Our ref: 22_07466_P

Your ref: H09-1091-22

Site name/Description: 23 Jekils Bank Holbeach
St Johns Spalding

Summary of Proposal: Erection of
bungalow

TITLE
PROPOSED SITE LAYOUT

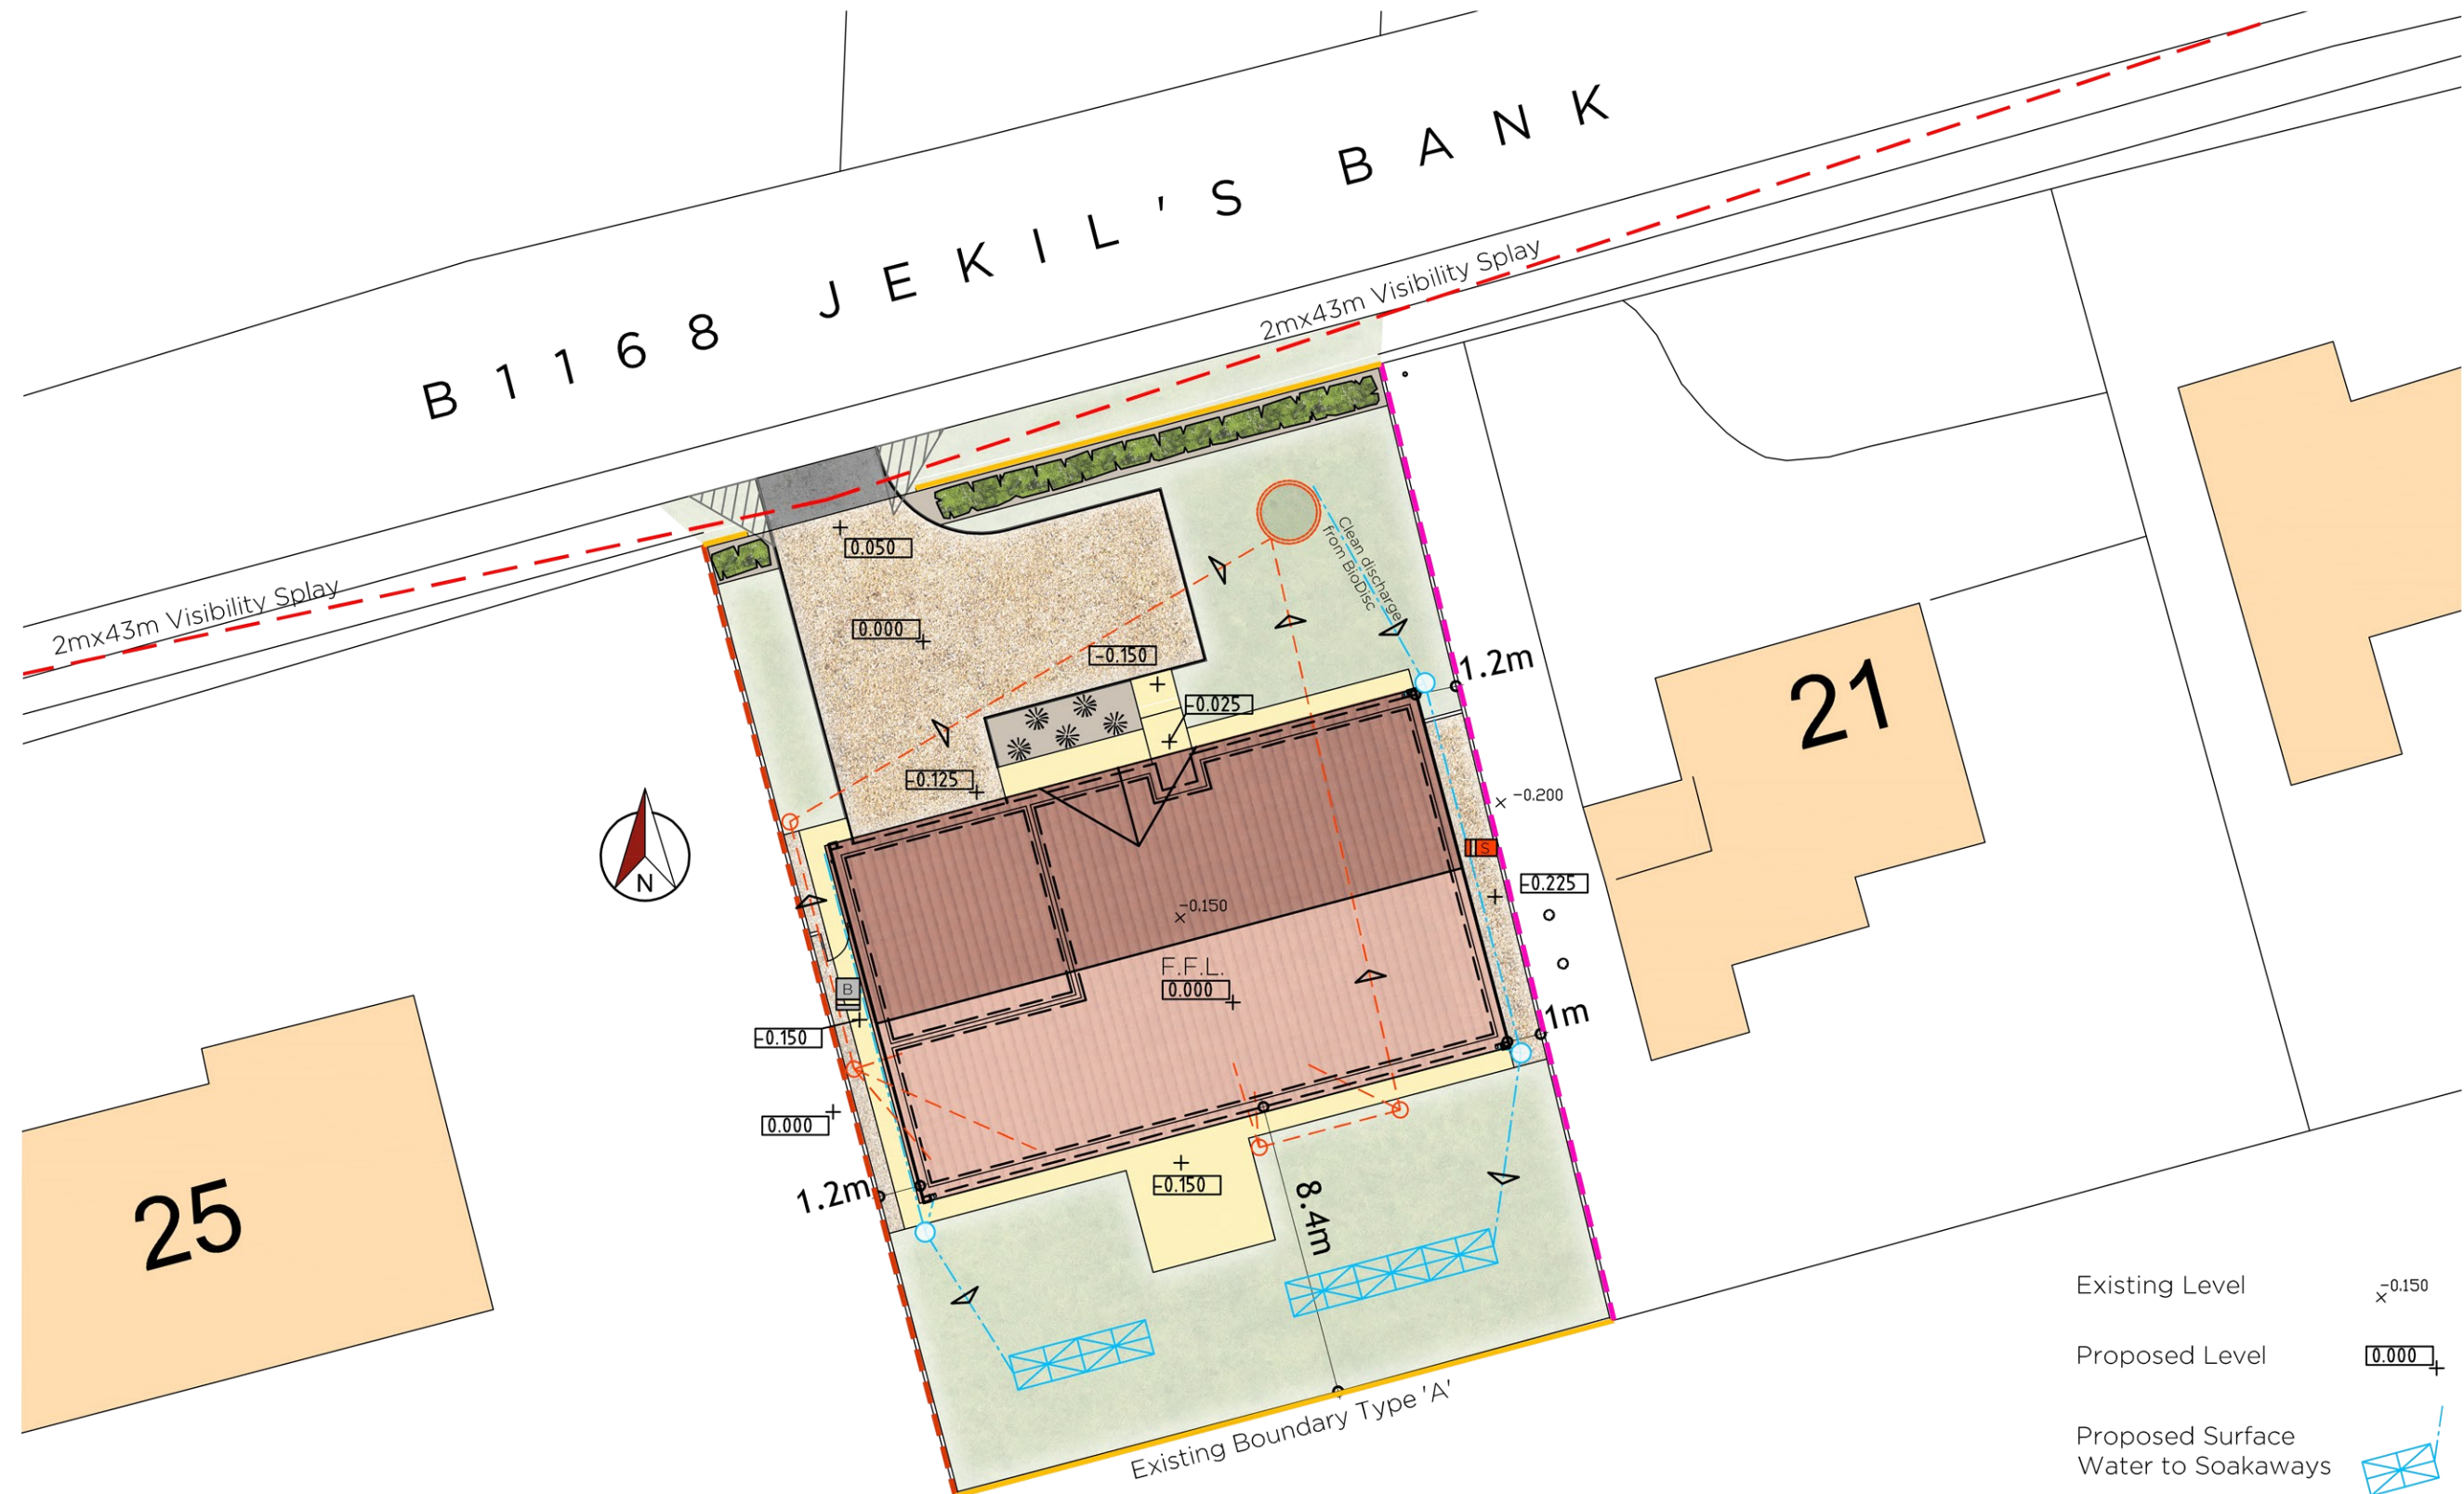
I note that the applicant intends to treat foul waste using a package treatment plant, however I cannot see that the applicant has indicated how they intend to dispose of treated foul water from this development. If the applicant proposes to discharge treated foul water to a watercourse, consent would be required under Byelaw 3.
